Appeal Decision

Appeal Ref: APP/R5510/D/23/3334238

32 Stafford Road, Ruislip HA4 6PJ

Drawing Title  
Roof Plans

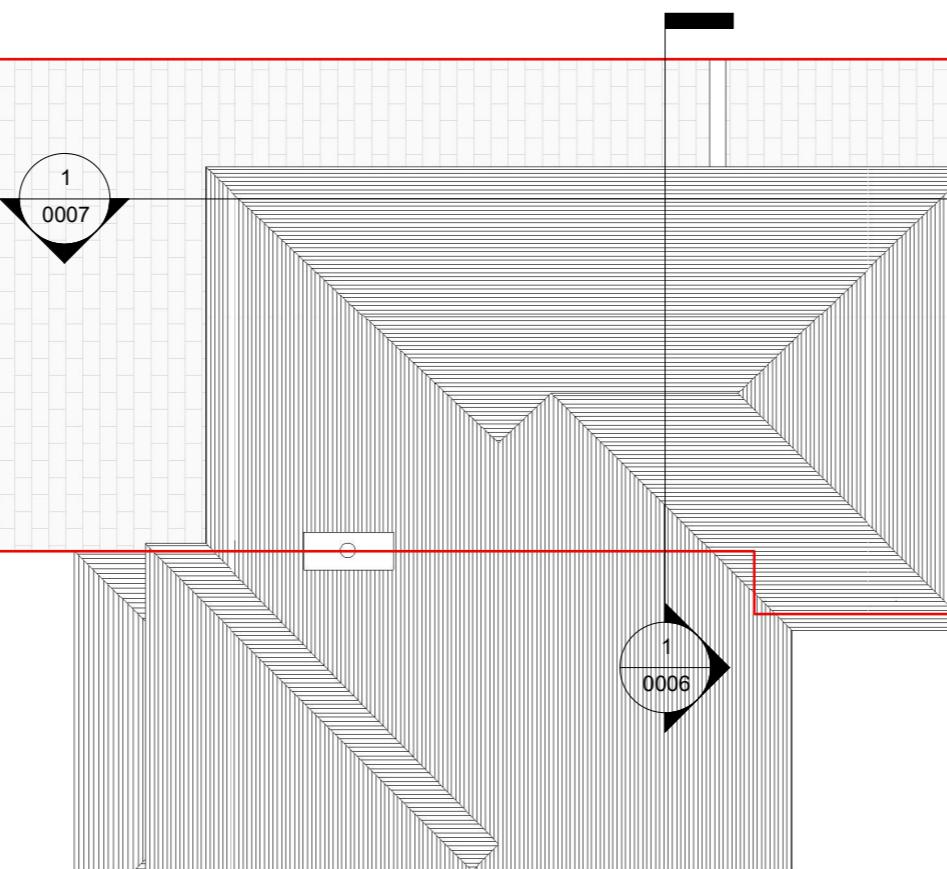
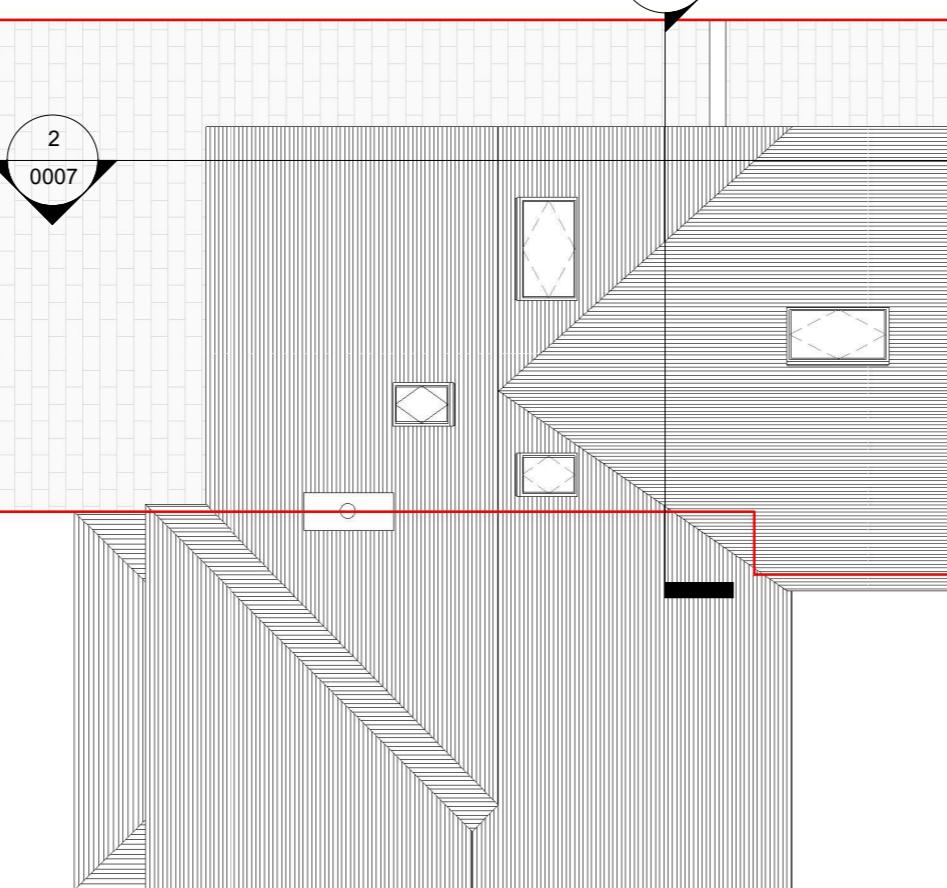
6. The proposed development includes roof extensions which would result in hipped to gable roof forms for the main roof and the roof above the 2-storey rear projection would also have higher ridge height and be asymmetrical in design. Whether these alterations to the roofs could be undertaken as permitted development is not a matter for determination as part of this appeal.

7. As identified by the Council, the proposed hip to gable extension of the main roof would result in an unbalancing of the symmetrical appearance of the terrace. This alone would not be a reason for this appeal to fail but when considered cumulatively with the visually dominant front hipped roof feature, the form and additional bulk of the proposed gable roof would have a significantly harmful impact on the character and appearance of the host property and the terrace when viewed from Stafford Road. The existence of the gable roof of No. 34 does not alter this assessment.

Drawing Title  
Rear Elevation

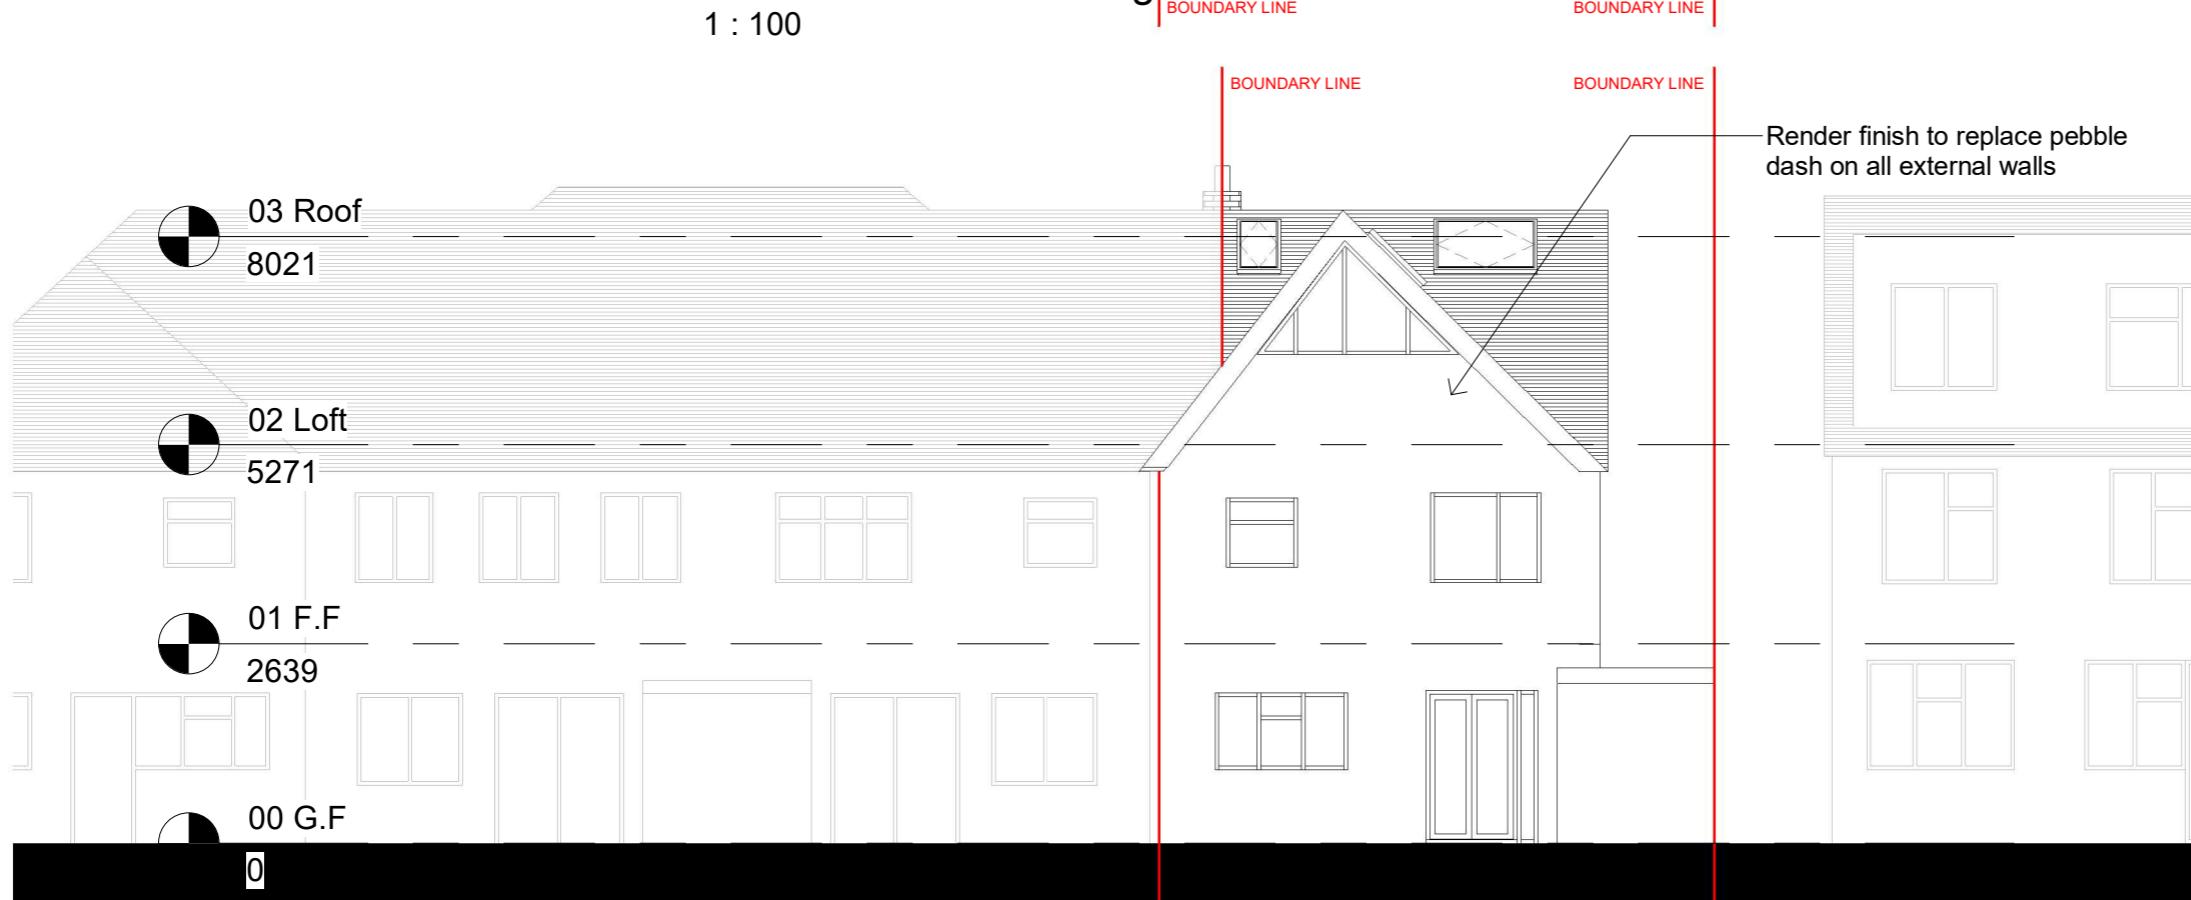
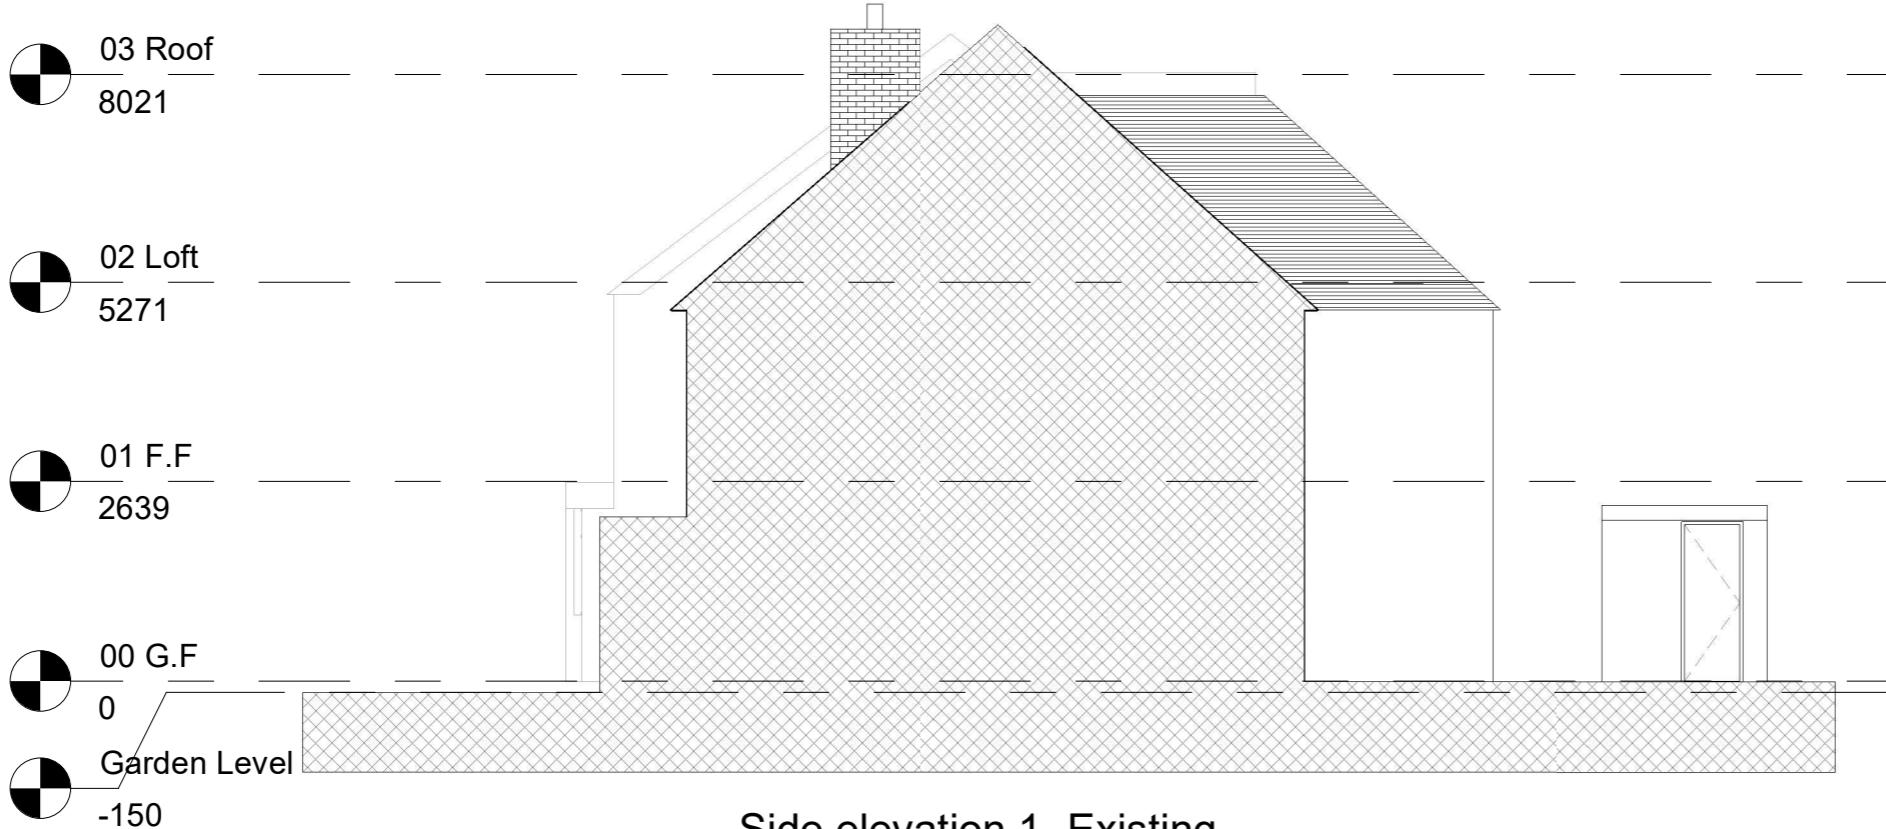
8. From Acorn Grove the proposed asymmetrical gable roof of the 2-storey projection would be seen alongside the alteration to the property's main roof. The ridge height of the roof would be increased to match the main roof. These alterations to the design, height and form of the property's rear roofs would result in the 2-storey projection possessing a visually dominant appearance which would have a detrimental effect on the character and appearance of the host property and terrace when viewed from Acorn Grove. This adds to the significant harm which has already been identified.
